Town & Country Planning (Control of Advertisement) (England) Regulations 2007 (as amended)

1x internally illuminated fascia sign & 1x internally illuminated projecting sign.

5 Arundel Road Littlehampton

ITEM A

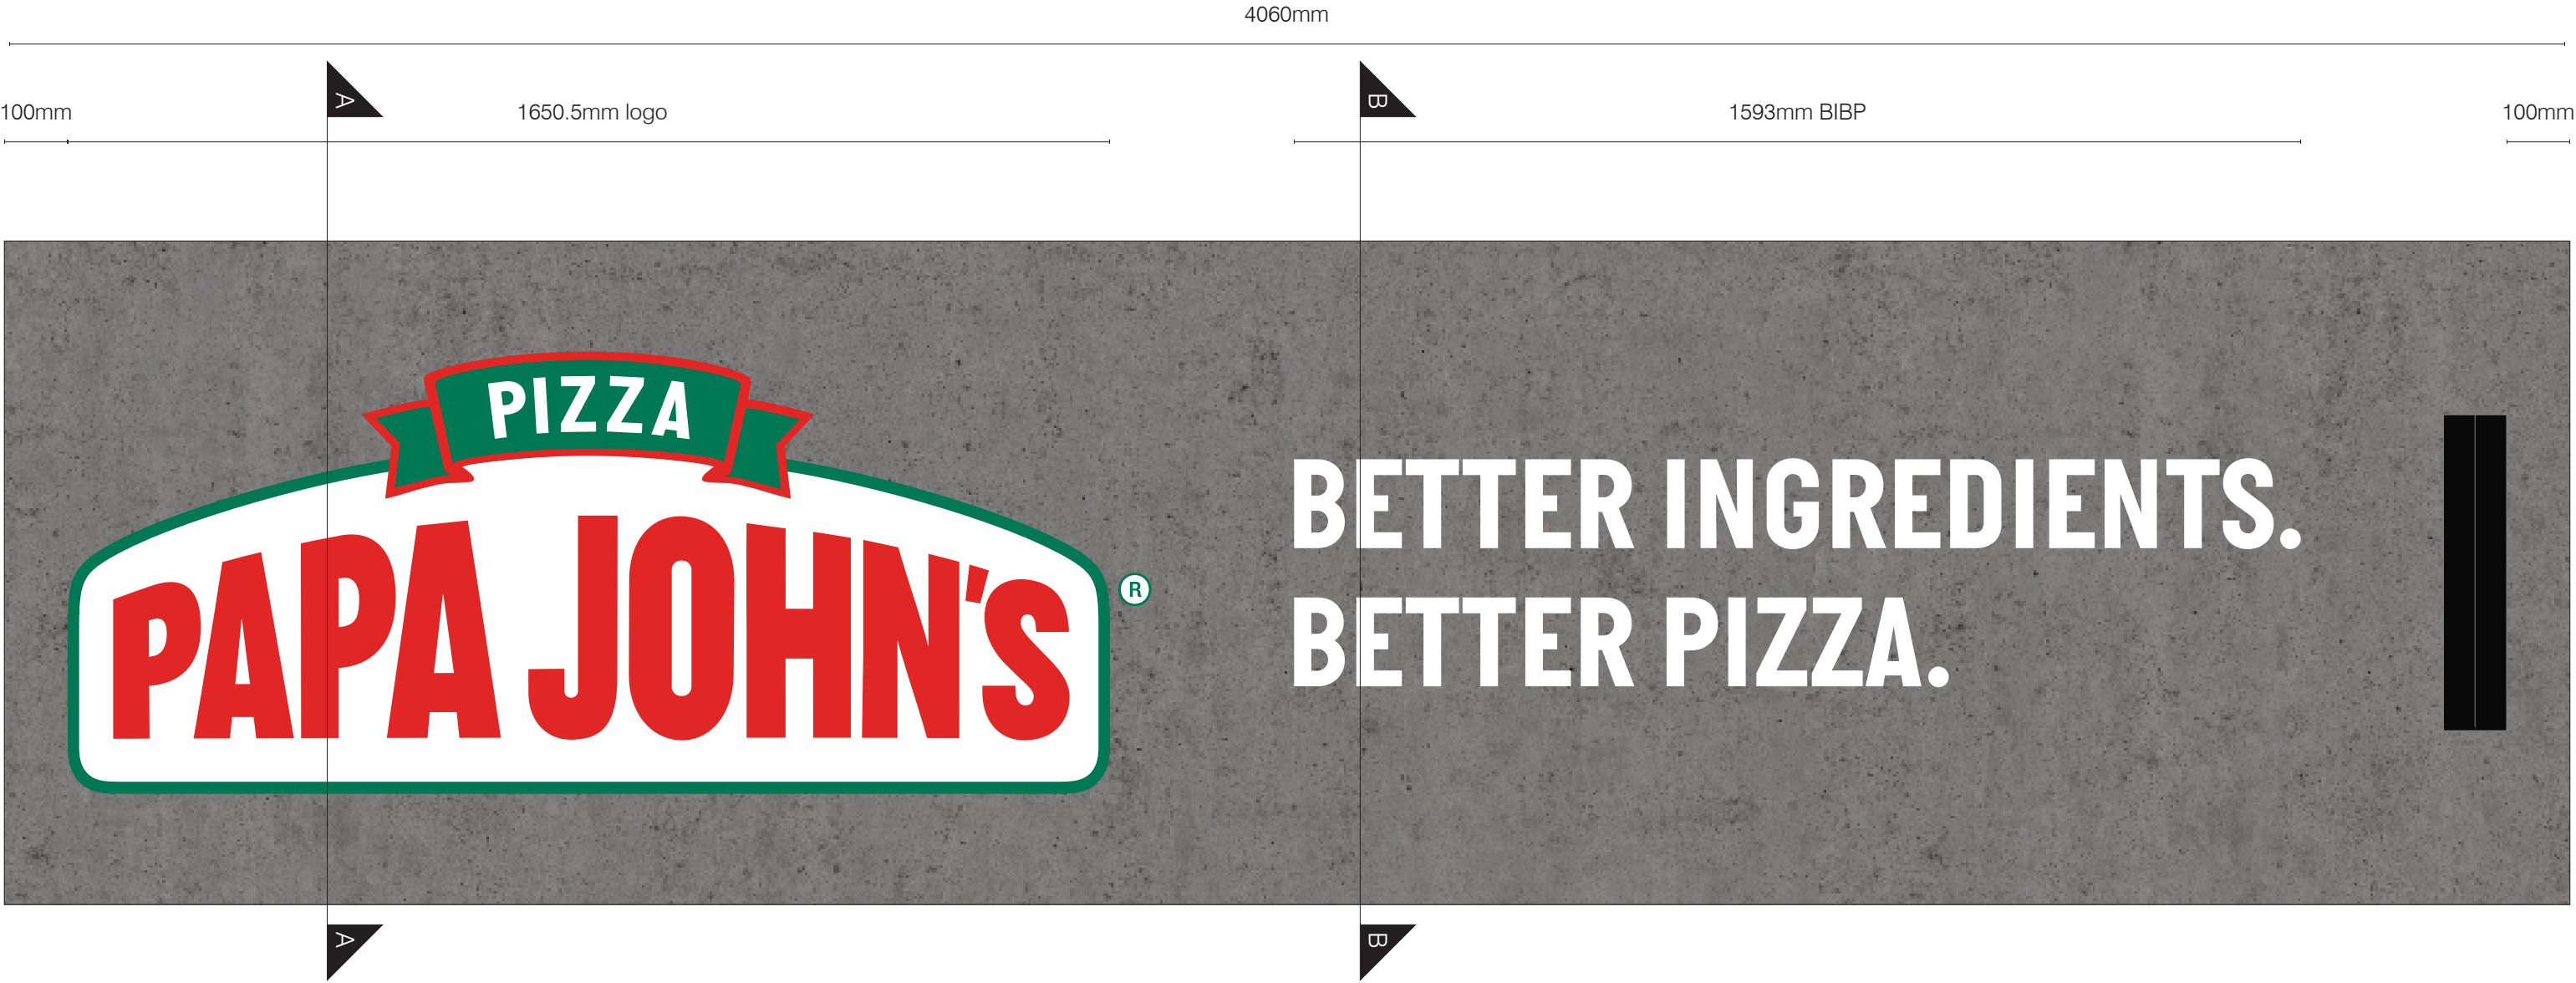
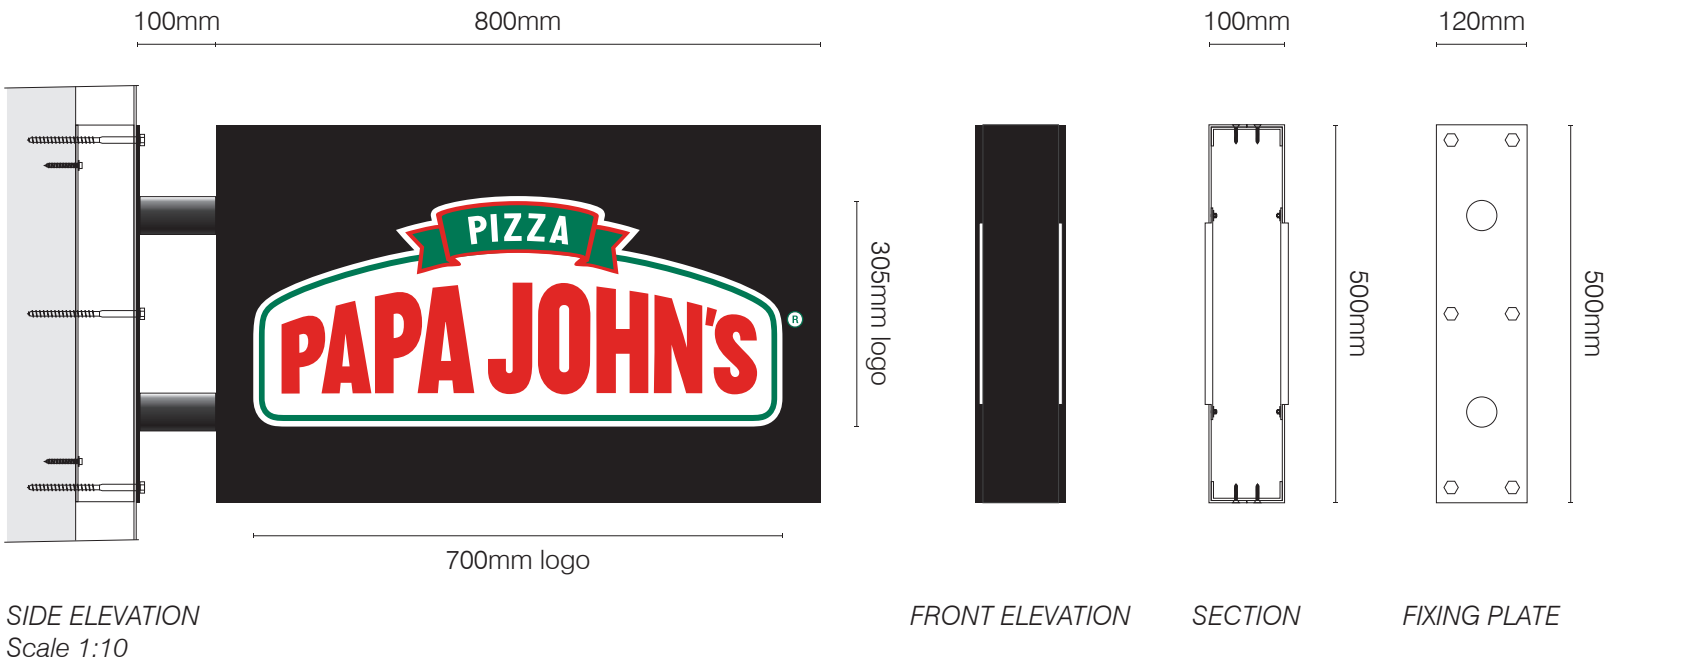
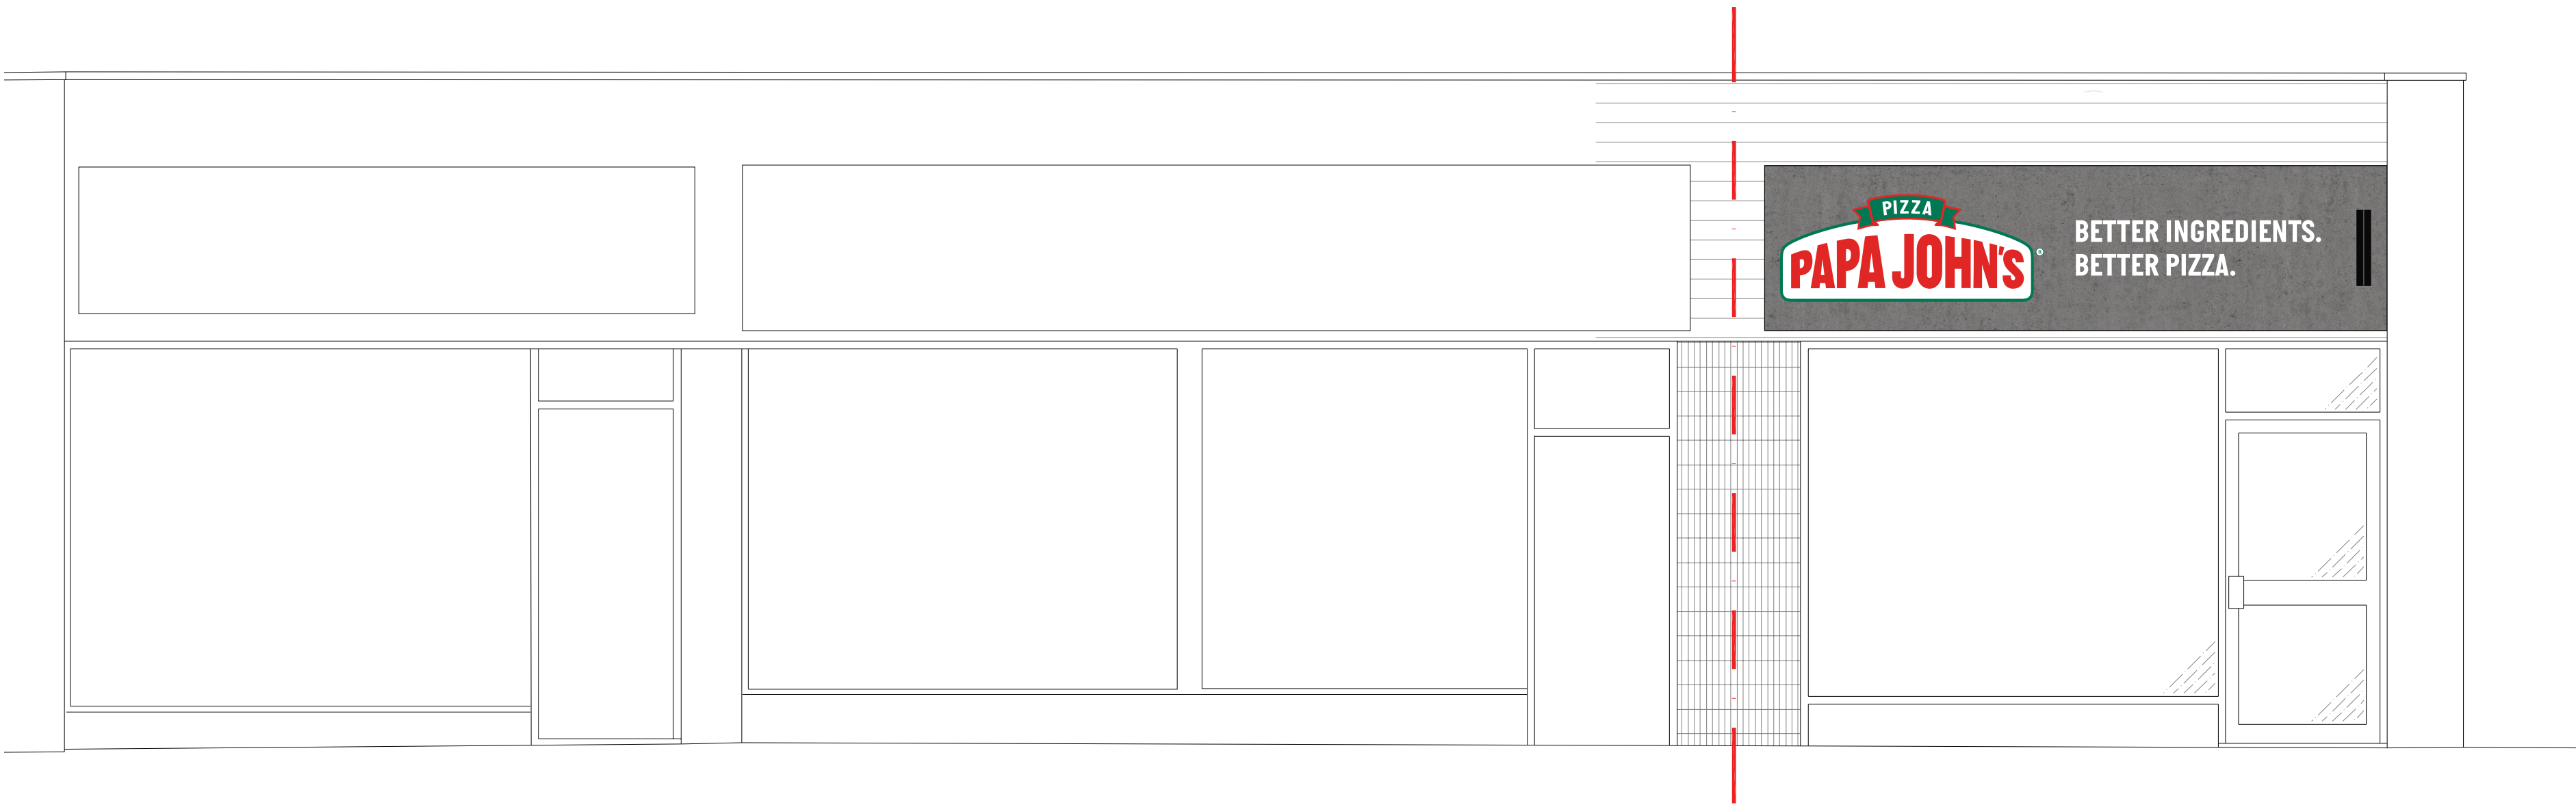
Despite fairly detailed supportive documents, I could not find details of how much NITS (brightness) the signage will be producing.

In which direction the light will travel ie. is the sign will project only forward? We are already have light pollution from the High Street.

Please clarify above, sign shouldn't exceed Ricara or Funeral services shop next door.
